From: Jeff Watson
Sent: Thursday, May 26, 2016 3:46 PM
To: 'dgray@grayse.gs'
Cc: 'shirley riste (bnsriste@gmail.com)'
Subject: FW: SP-15-00007 Riste Mylars

SP-15-00007 Riste

PW had the following comment RE: the mylars for the above short plat:

RISTE SHORT PLAT SP-15-00007

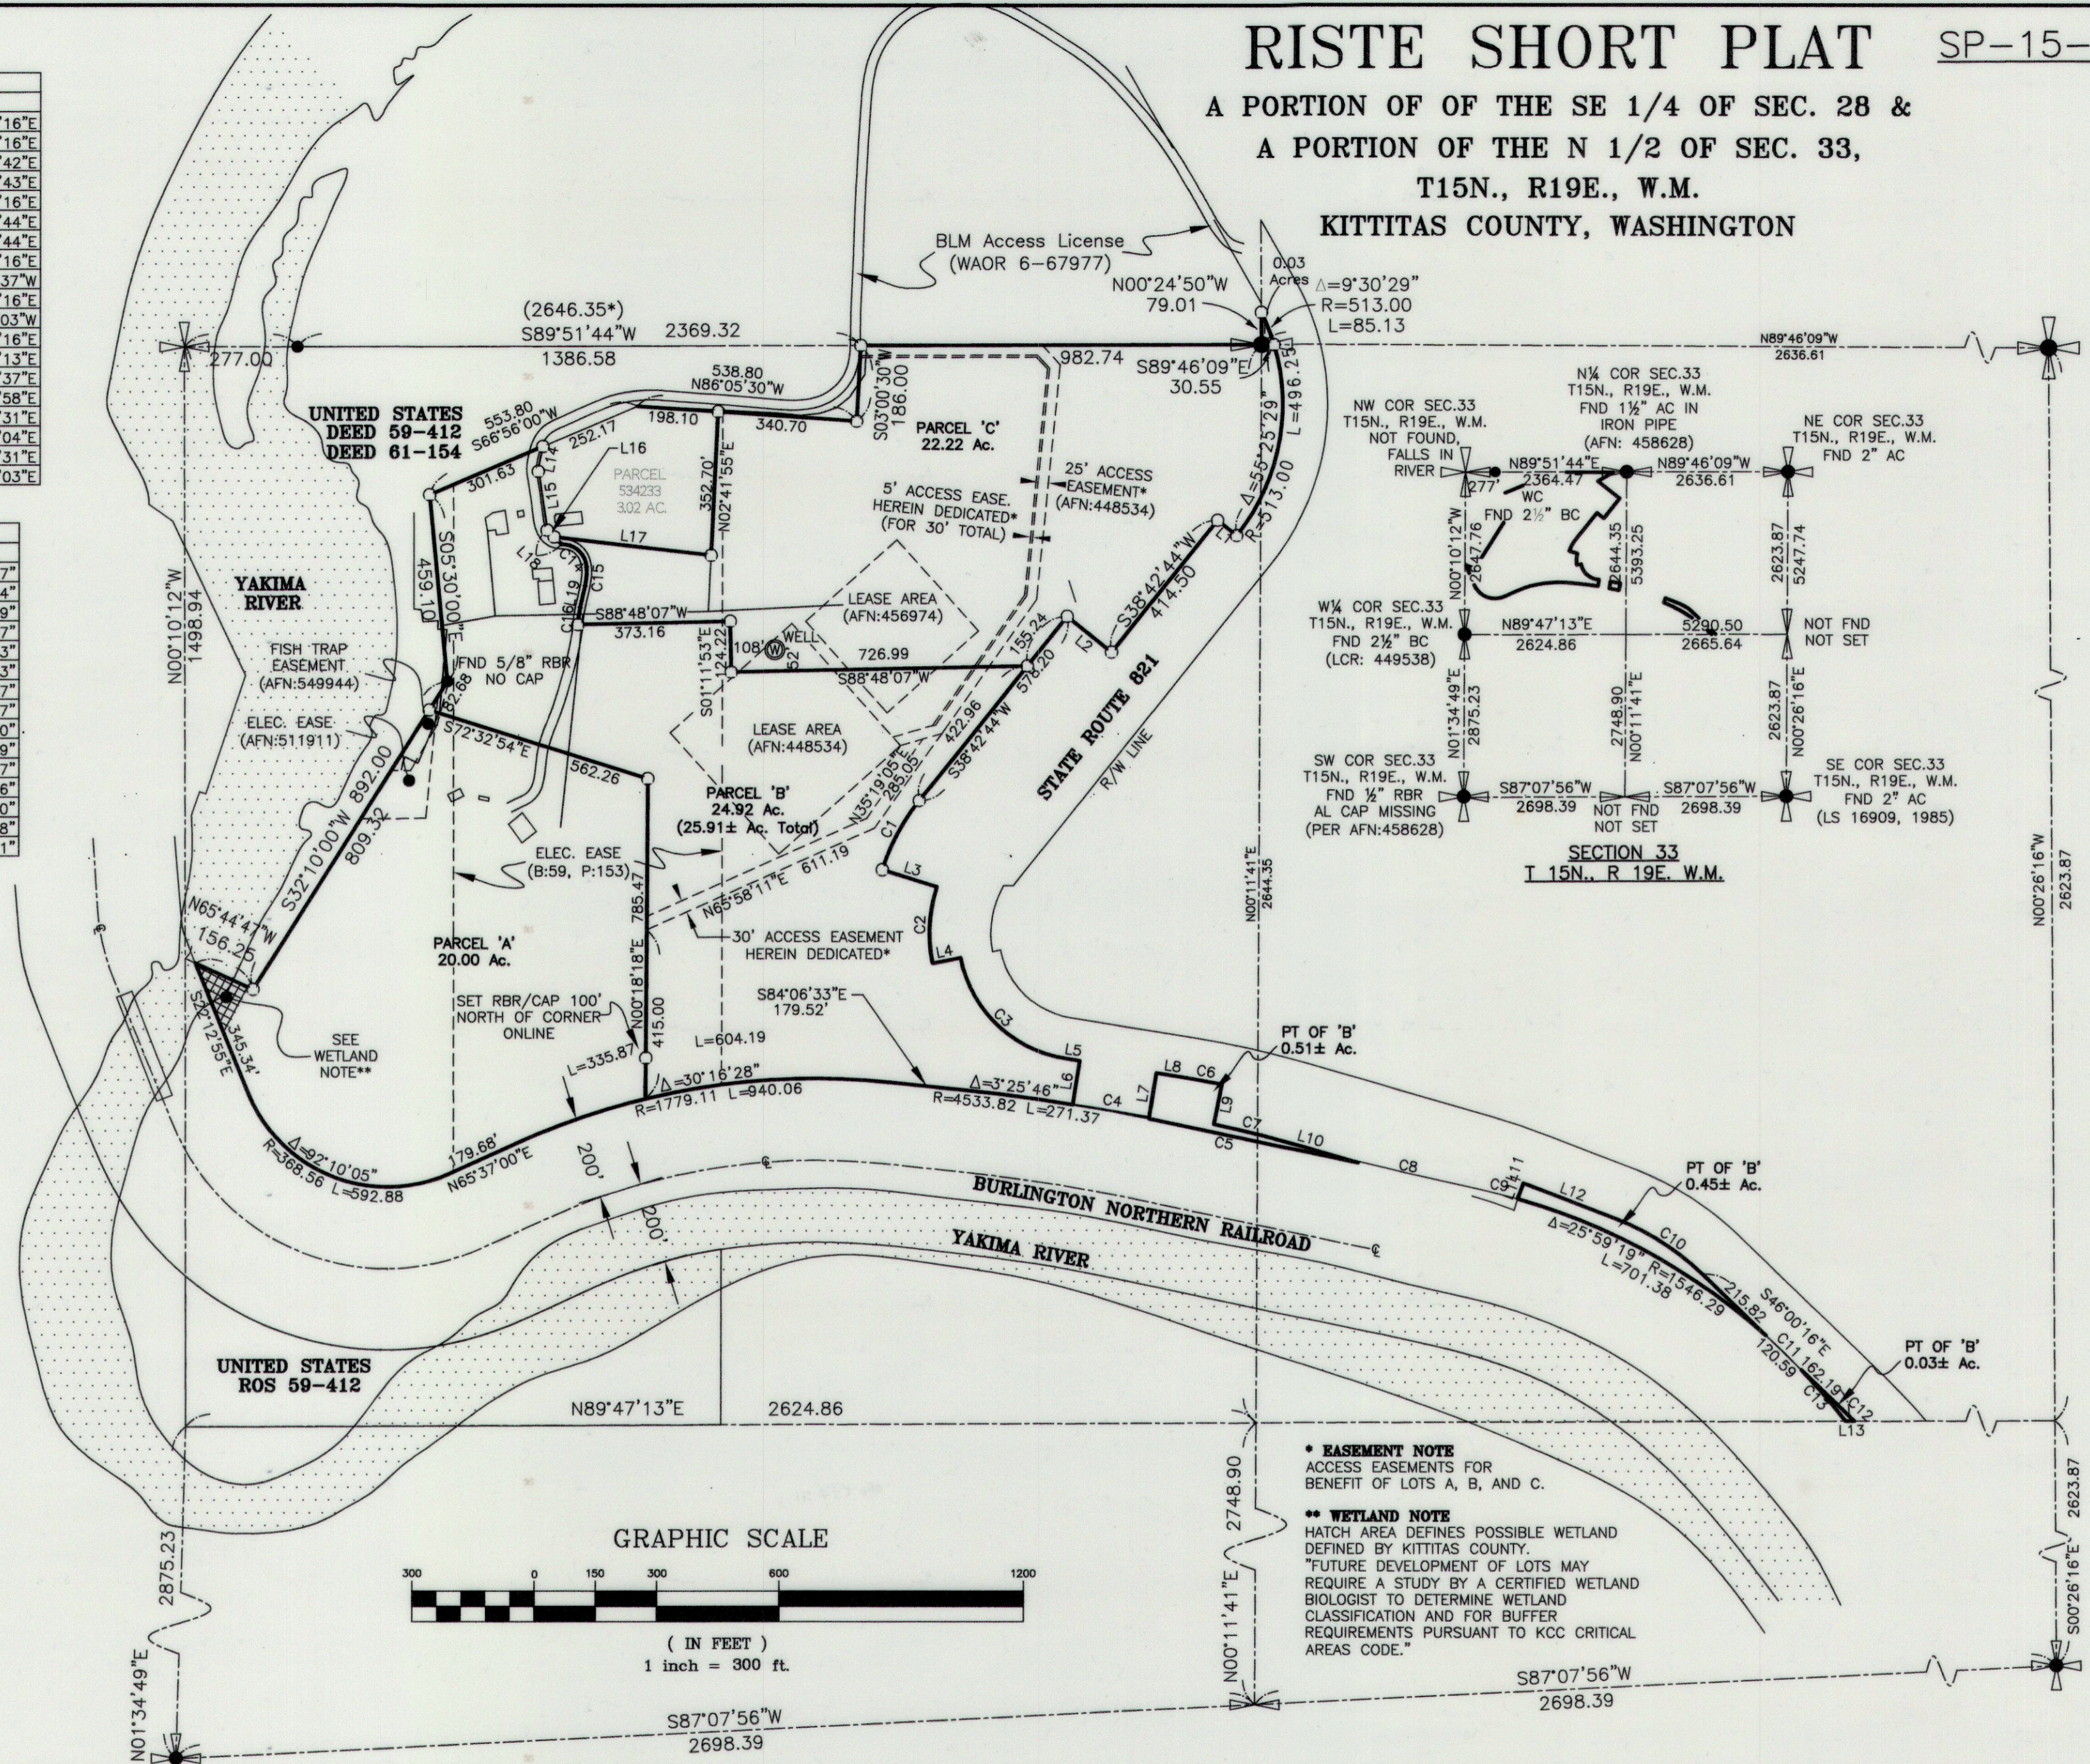
The only comment I have is that the driveway to Parcel A shows on the face of the Short Plat but does not have an easement. They did include an easement through Parcel C and B to Parcel A, but it does not travel the existing driveway.

Of all of the requirements, all but the highlighted versions are complete for these mylars.

16. Well location. The drawings shall be marked with a "w" indicating location of the well and a broken line showing the one hundred foot radius around such.

All wells must meet the distance requirement of 50 feet from the property line, 50 feet from the septic tank and 100 feet from the drain field as per Kittitas County Critical Areas Ordinance 17A.08.25, and KCC Chapter 13. If existing wells do not meet the setback requirement from property lines, the two adjoining parcels nearest the well must enter into a legal, shared well-users agreement.

“Metering is required for all new uses of domestic water for residential well connections and usage must be recorded in a manner consistent with Kittitas County Code Chapter 13.35.027 and Ecology regulations.”
